V1Lighting Plan.pdf Markup Summary

Subject: Text Box
Page Label: [1] Outlook Powers & Grinnell-SDP-24
Author: Kishia
Date: 6/21/2023 11:03:38 AM
Status:
Color: ■
Layer:
Space:

SITE PHOTOMETRICS

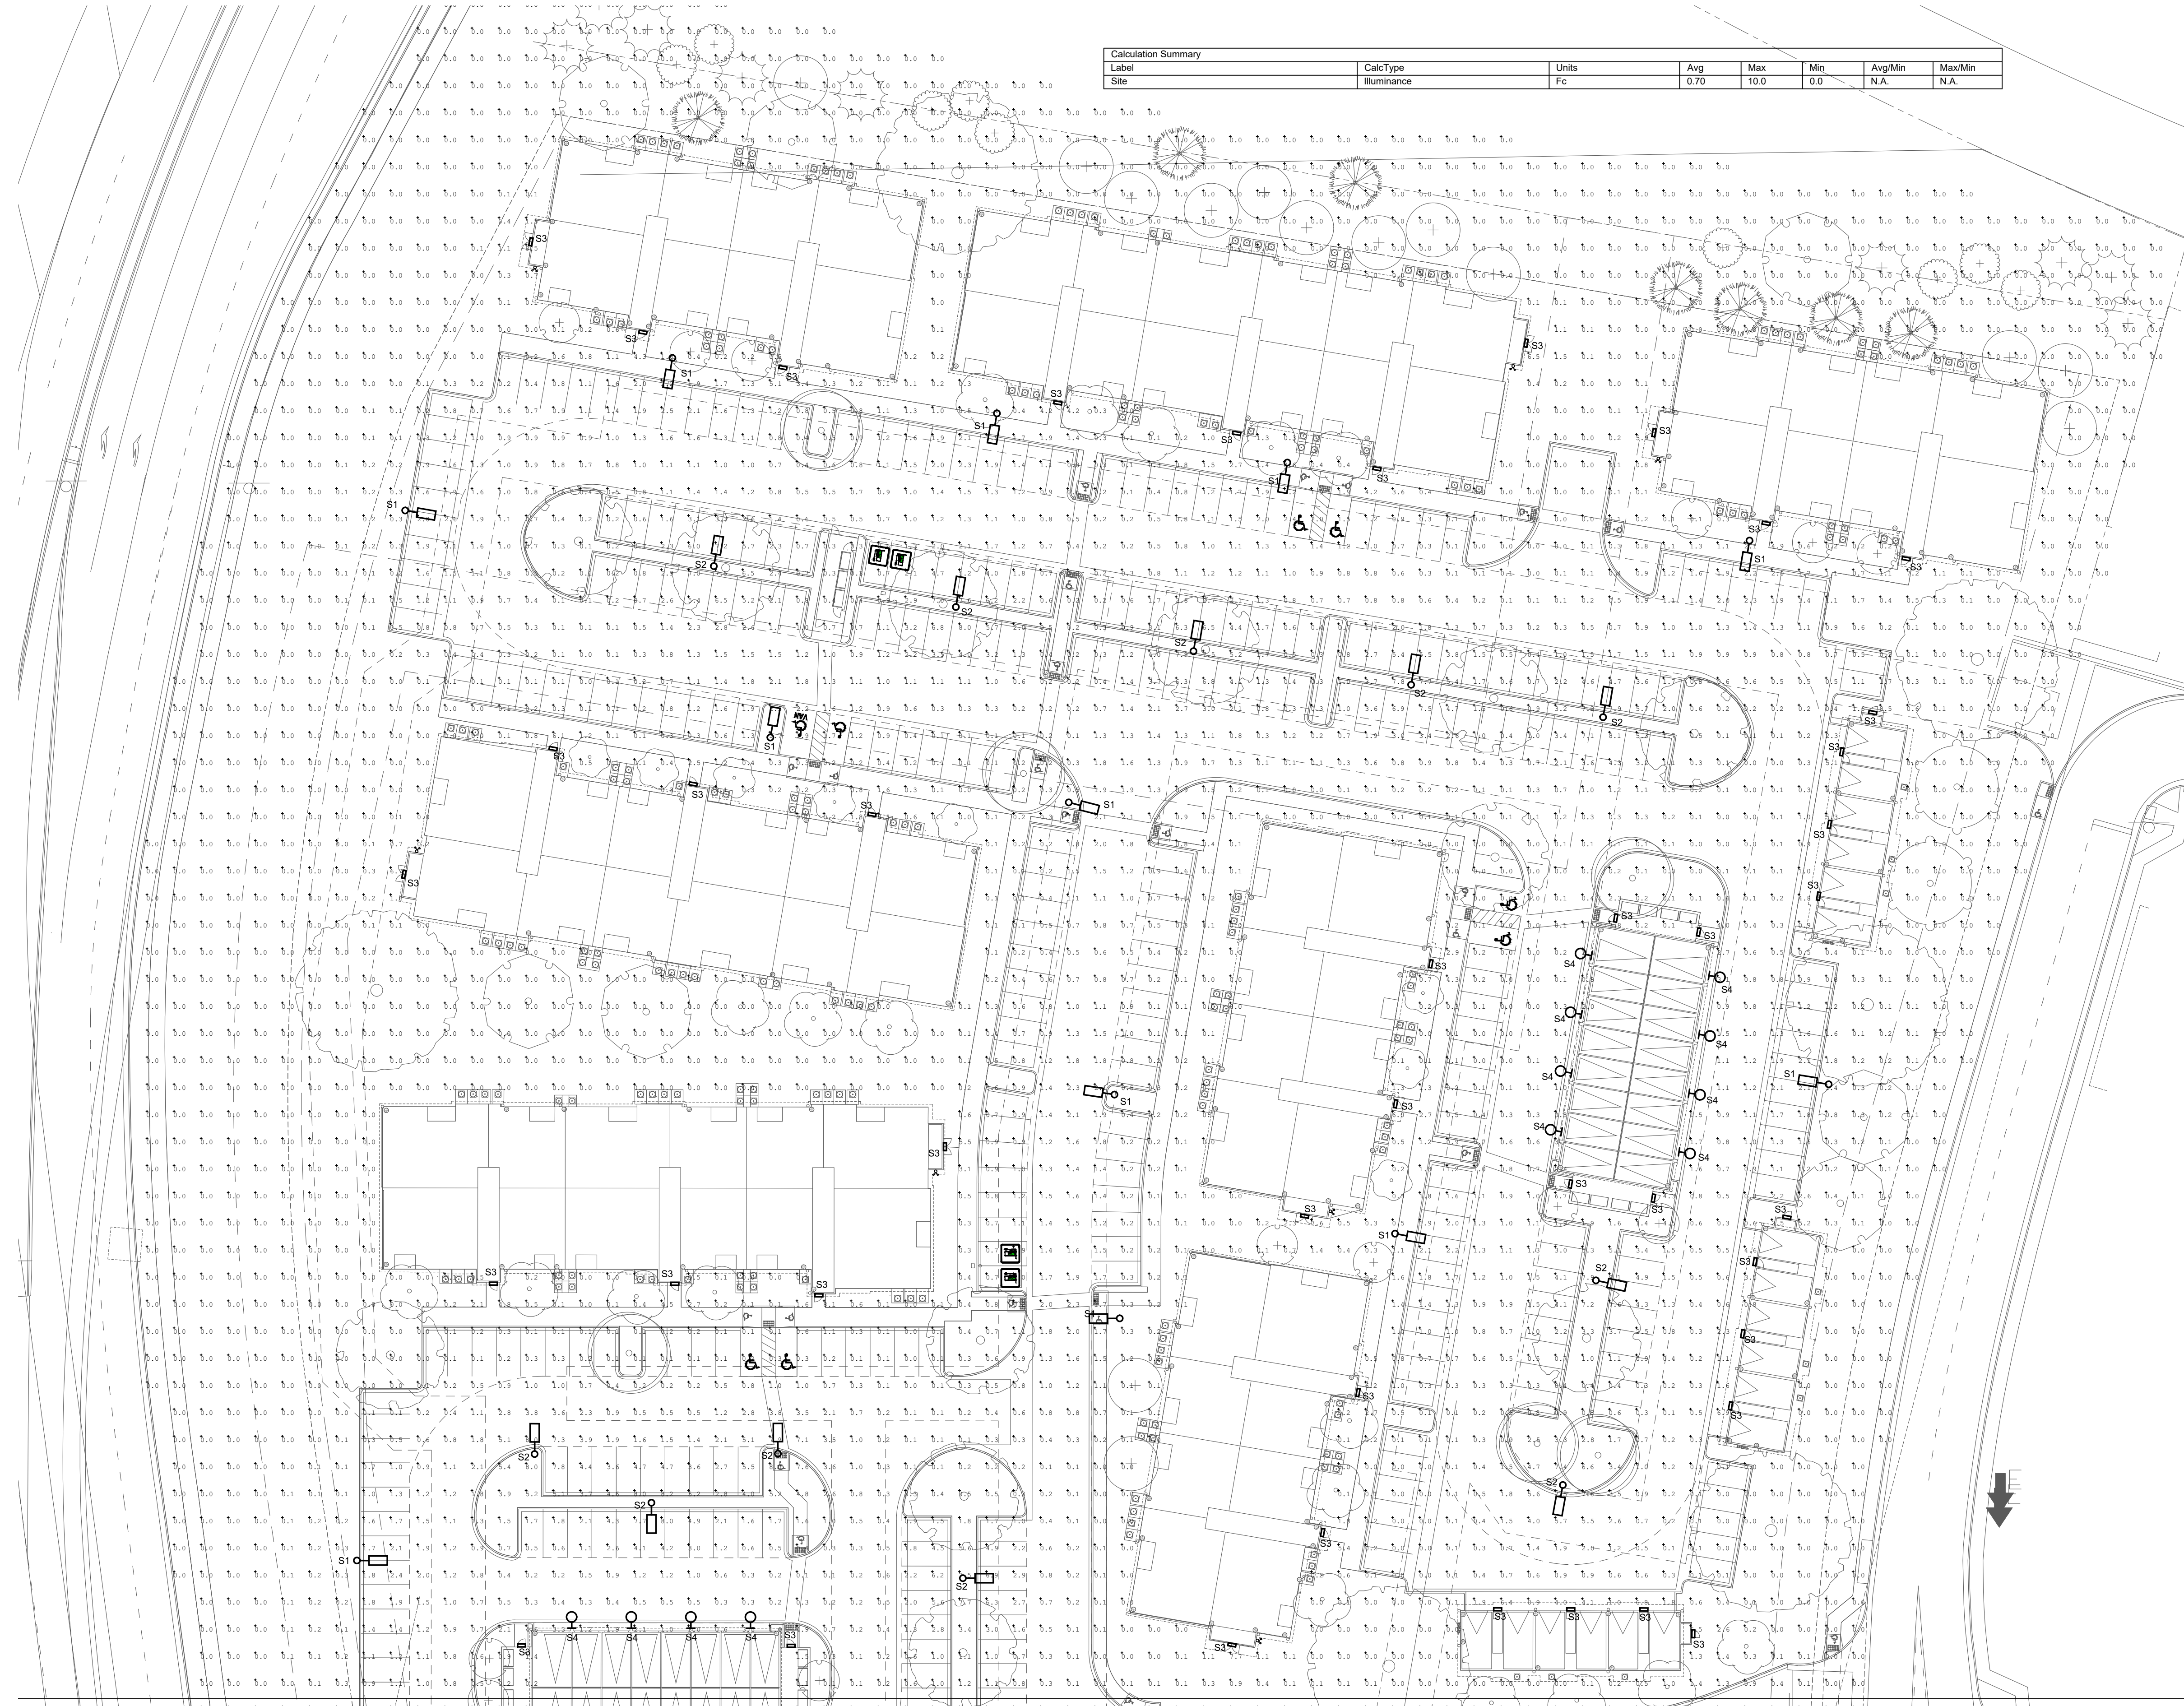
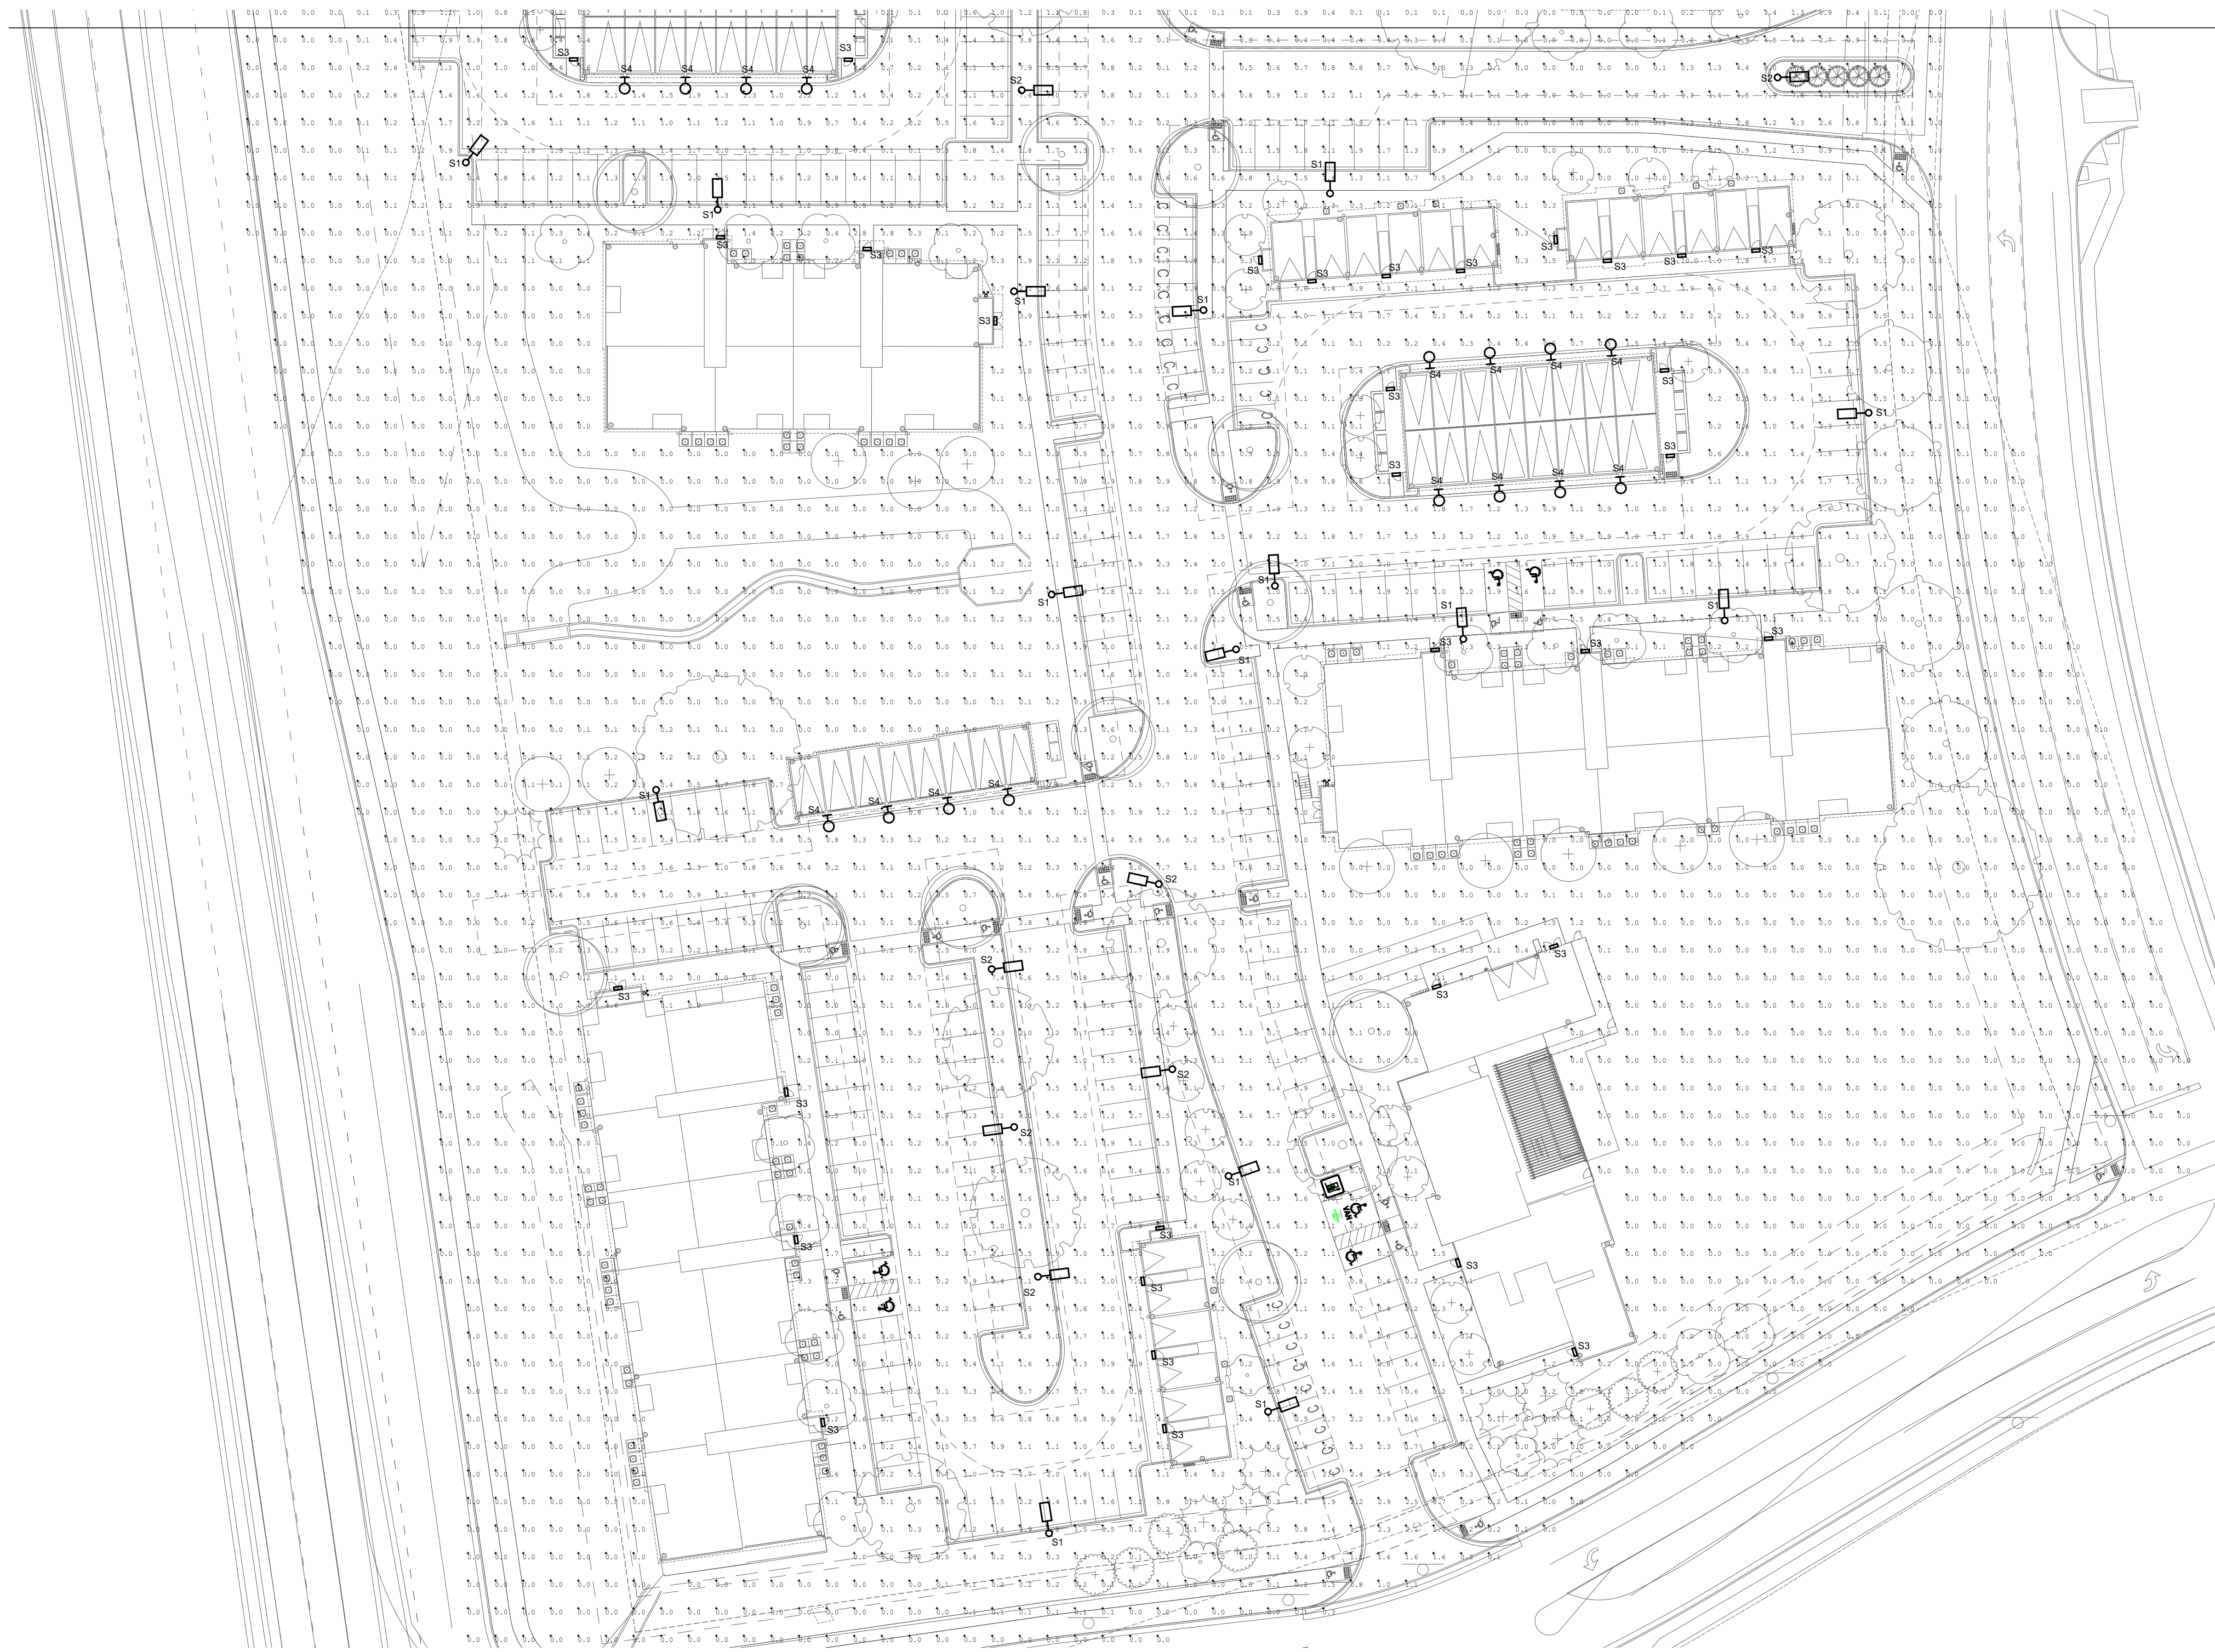
You need to provide a legend on each page of the Site development plan .
That needs to include all of the symbology depicted in the images provided with this application .
